BOTLEY WEST SOLAR FARM
PLANNING ACT 2008
INFRASTRUCTURE PLANNING (APPLICATIONS: PRESCRIBED FORMS AND
PROCEDURE) REGULATIONS 2009

SBW's WRITTEN SUBMISSIONS FOR DEADLINE 7

Deadline 7 Submissions

10 November 2025

**rpsgroup.com**  
101 Park Drive, Milton Park, Abingdon, Oxfordshire, OX14 4SH  
T: +44(0)1235 821 888 E: rps.ox@tetratech.com

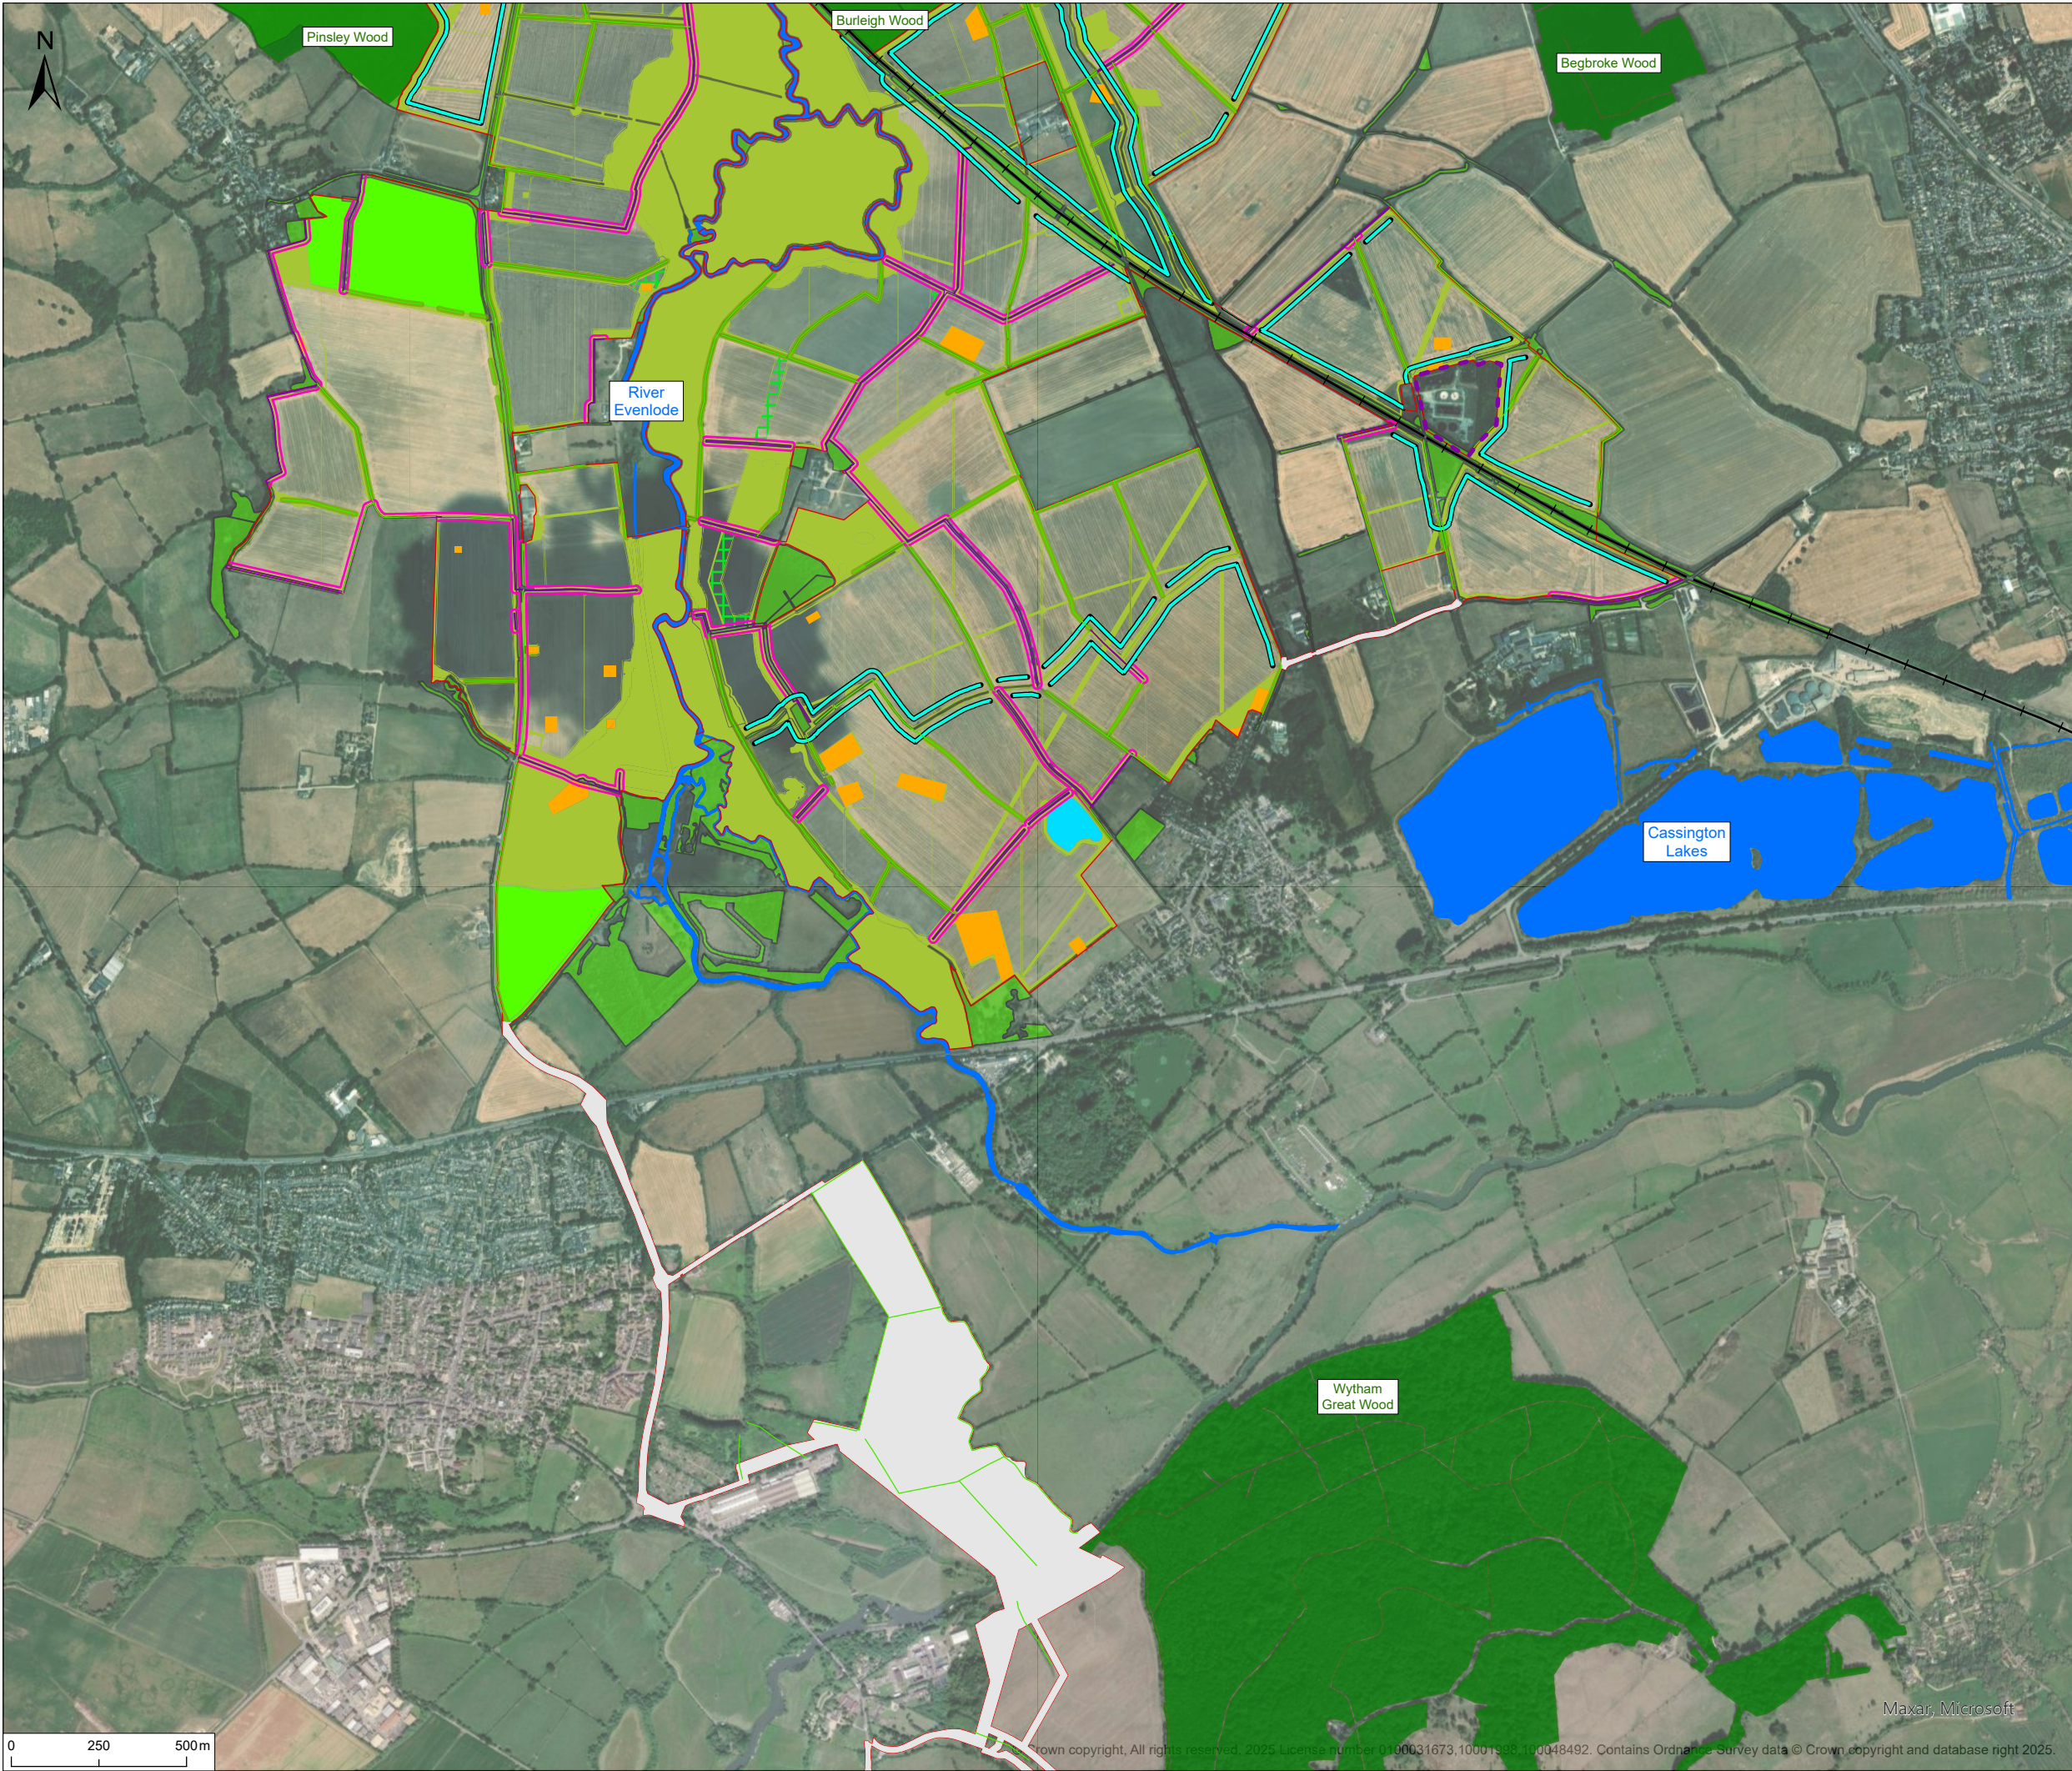
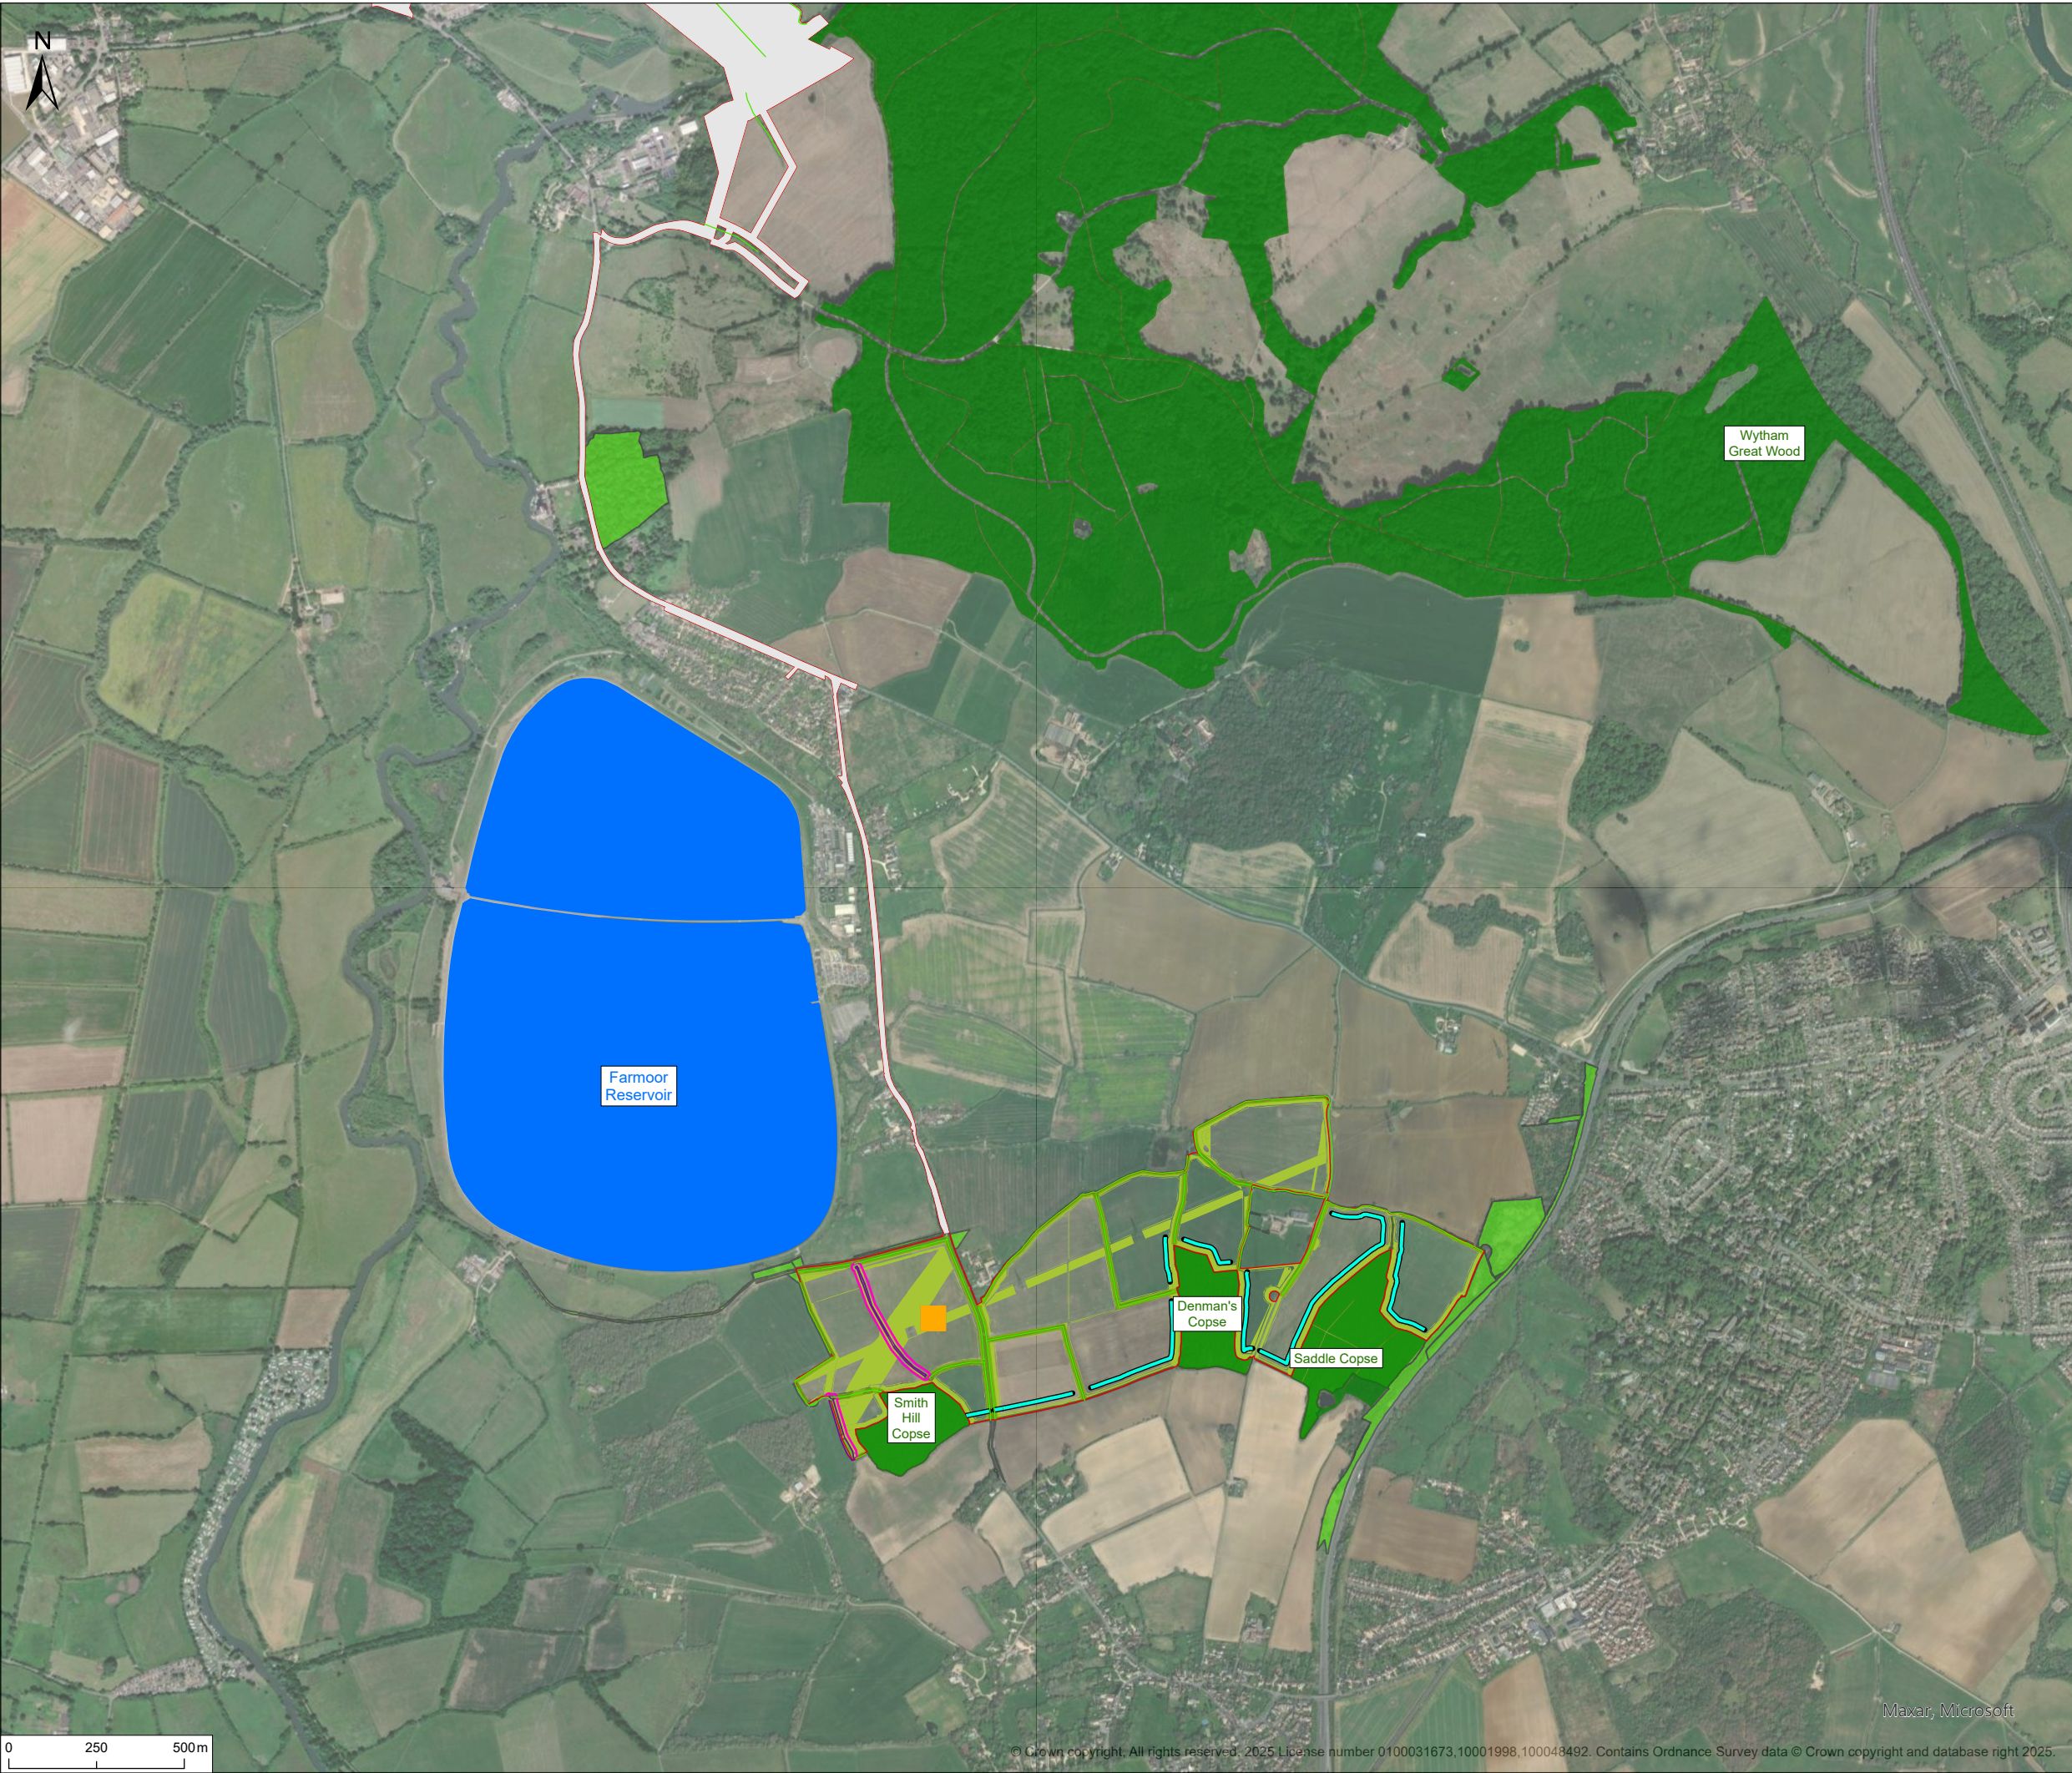
- ii. **Bats.** The Applicant relies on a tiered buffer concept but, as the Host Authorities highlight, Tier A bat flightline buffers are not yet mapped to a level that secures their locations and extents on a plan. The buffers also do not offer any protection for bats that use arable fields for foraging, such as noctules, and thus the outlined strategy will only offer partial protection to bat communities with the Red Line. Monitoring commitments should run for then project lifetime and encompass both flightlines and array areas, yet the Applicant’s proposals remain non-committal and time-limited.
